***MODIFICATION REQUEST:
Hurstville Private Hospital
37 Gloucester Road, Hurstville
(MP 11_0042 MOD 2)***

Modification to the internal layout, changes to the façade, increase in height of the lift shaft and expanded plant area on the rooftop

Secretary's Environmental Assessment Report
Section 75W of the *Environmental Planning and
Assessment Act 1979*

December 2014

2 SUN STUDY - JUNE 12:00 PROPOSED AND EXISTING
DA-60 Scale 1:500

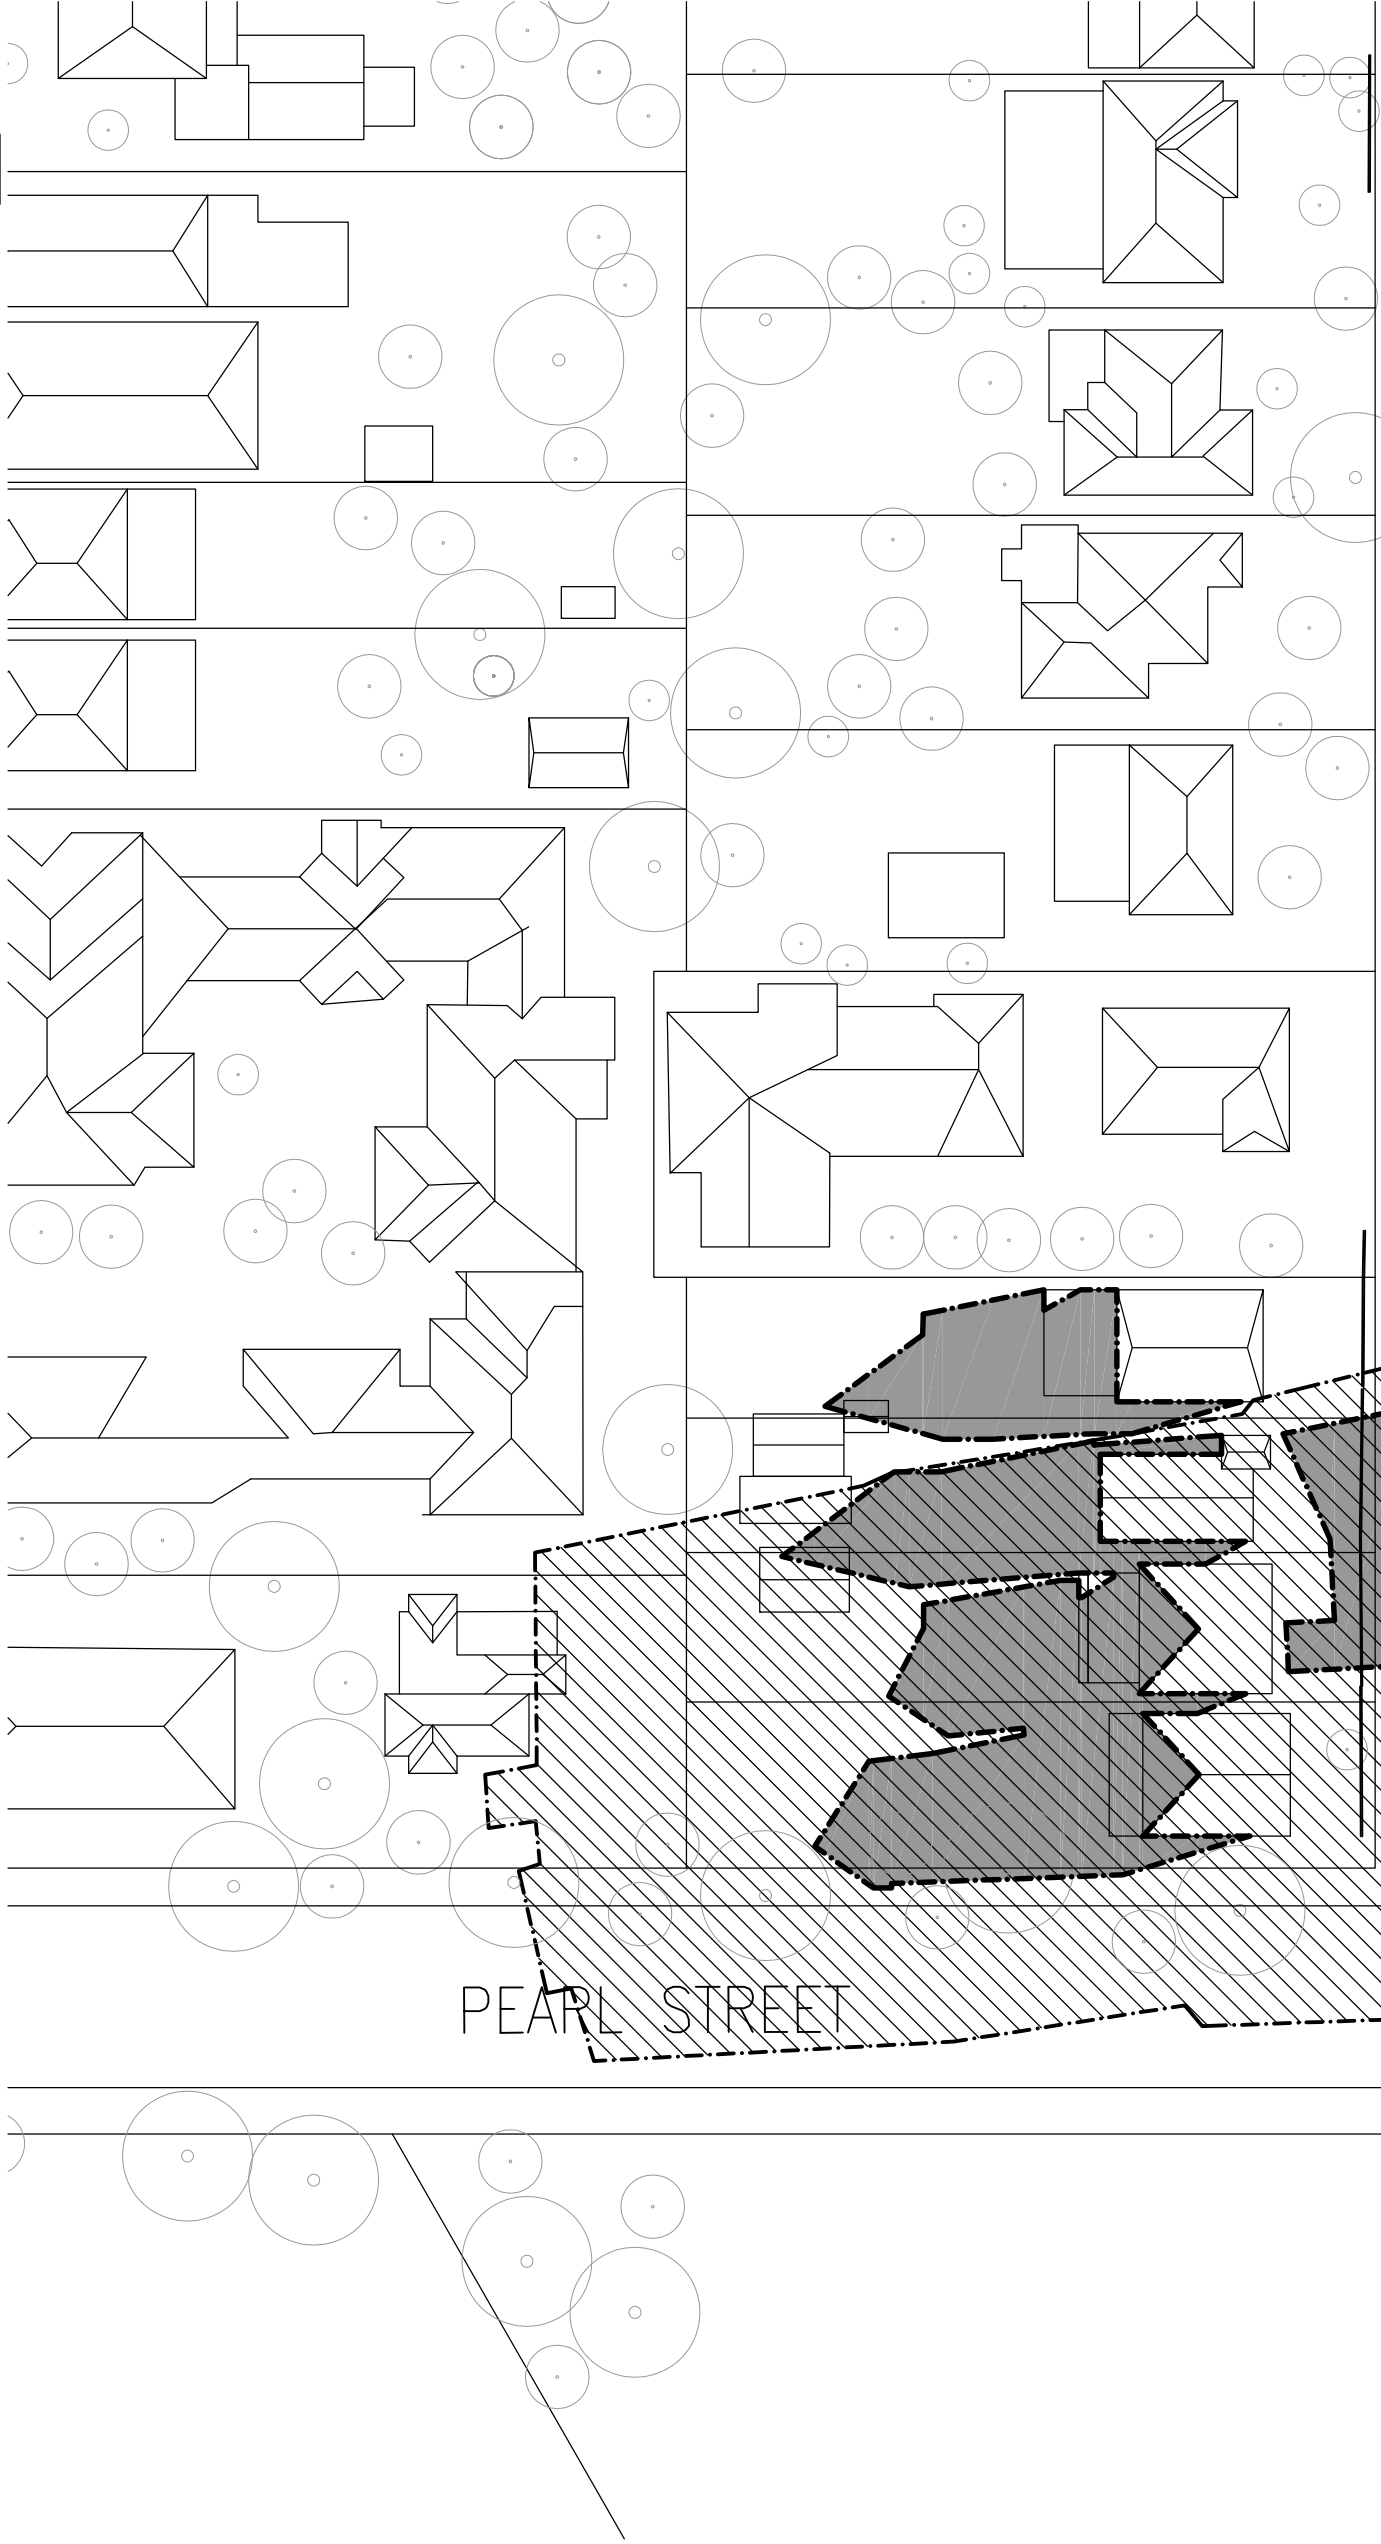
The additional height associated with the lift core also has the potential to adversely impact on the amenity currently enjoyed by the adjoining low scale residential properties directly to the south-west, fronting onto Millett Street. The proposed additional height would be readily visible above the parapet of the main building from these properties. However, the additional height would be offset by the removal of the link-way at the base of the lift core (as a consequence of the link corridor being relocated to the Gloucester Road side of the core), which would introduce a more slender building form (see **Figure 4**). The additional height associated with the lift overrun would also introduce some articulation to the roof line and assist in breaking up the mass of the building when viewed from the rear of the adjacent residential properties. Shadow diagrams submitted with the modification application demonstrate that there will be negligible additional shadow impacts on the rear of residential properties in Millett Street.
